**Our Case Number: ABP-309770-21**

**Re: Proposed development of up to 15 wind turbines with a tip height of up to 175 metres and laying of approximately 26km of underground electricity cabling to facilitate the connection to the national grid, and all associated site development works  
Townlands of Camagh, Carlanstown, Coole, Clonrobert, Clonsura, Doon, Monktown, Mullagh, Newcastle and other townlands, Co. Westmeath**

Your Ref: **ABP-309770-21**

**Proposed Strategic Infrastructure Development (SID):** SID application by Coole Windfarm Ltd. for a 15 turbine windfarm and associated works at Coole and other Townlands, County. Westmeath.

Habitat Map	
Project Title Coole Wind Farm, Co. Westmeath	
Drawn By HW	Checked By LK
Project No. 200445	Drawing No. Figure 4-1
Scale 1:15000	Date 2021.01.27

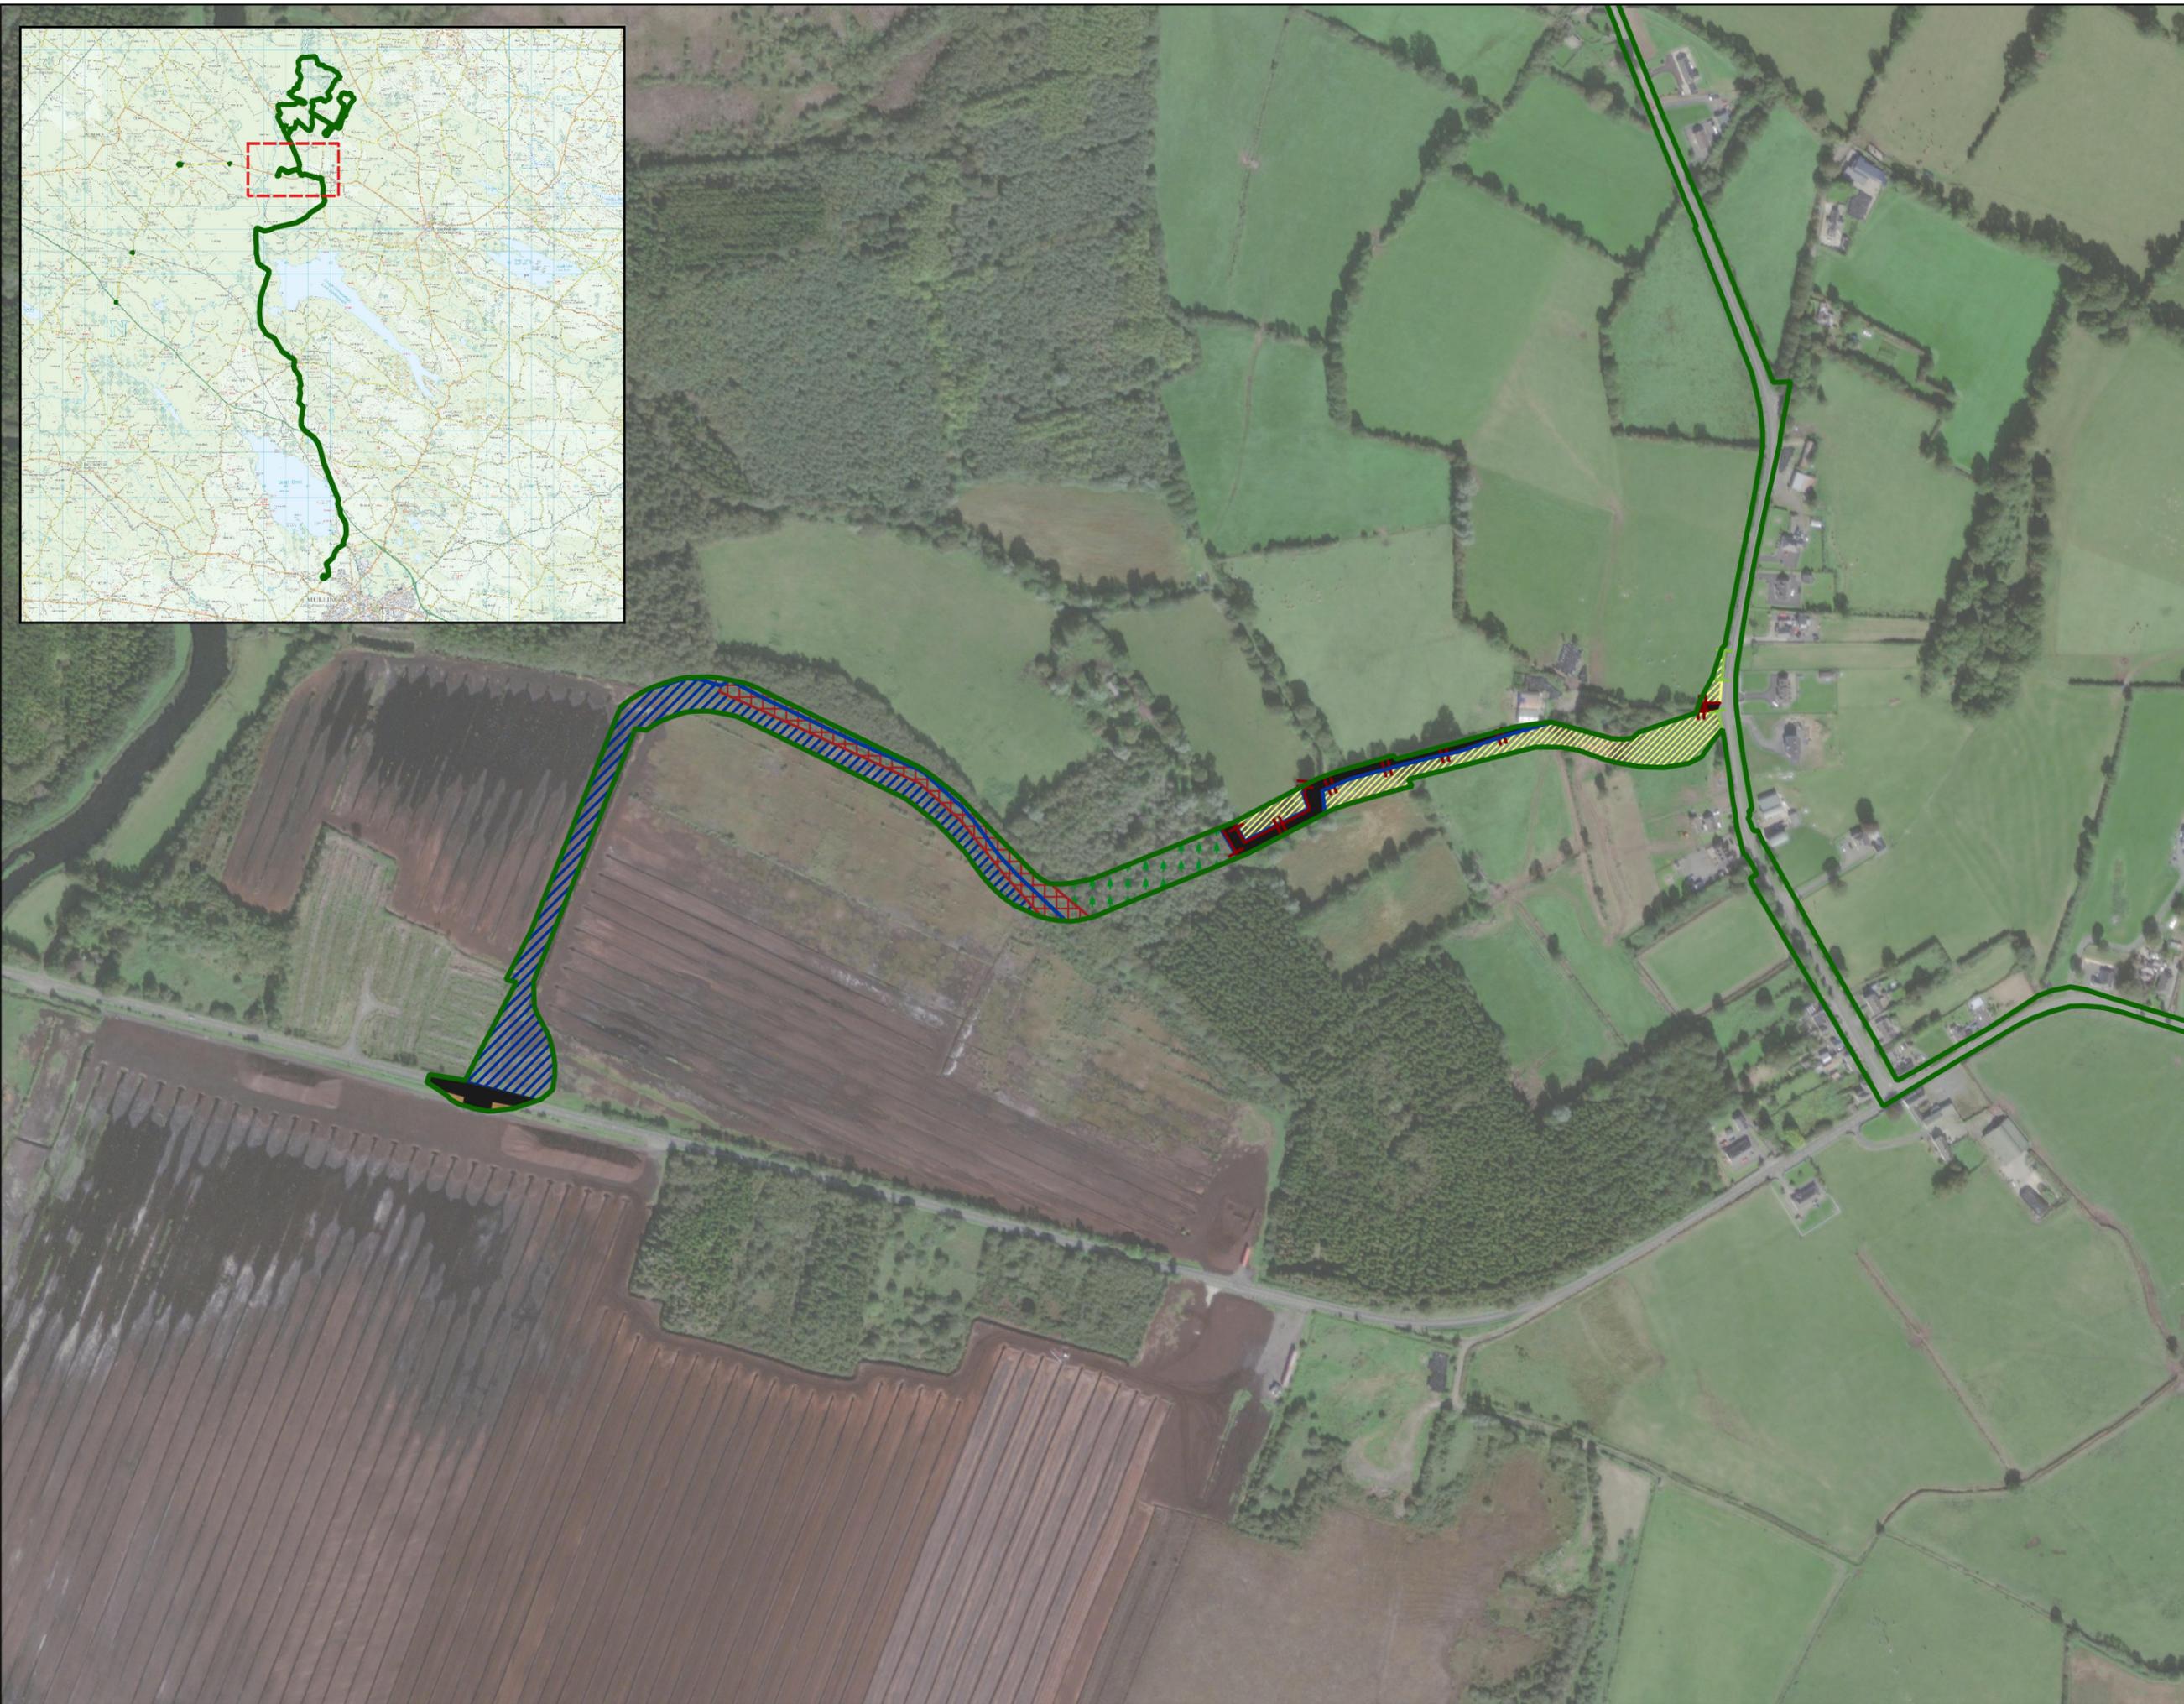
The Department acknowledges the detailed habitat survey information provided, however clarification is requested about the habitat identified as PB1 on page 34 of the NIS and whether this habitat equates to Annex I habitat.
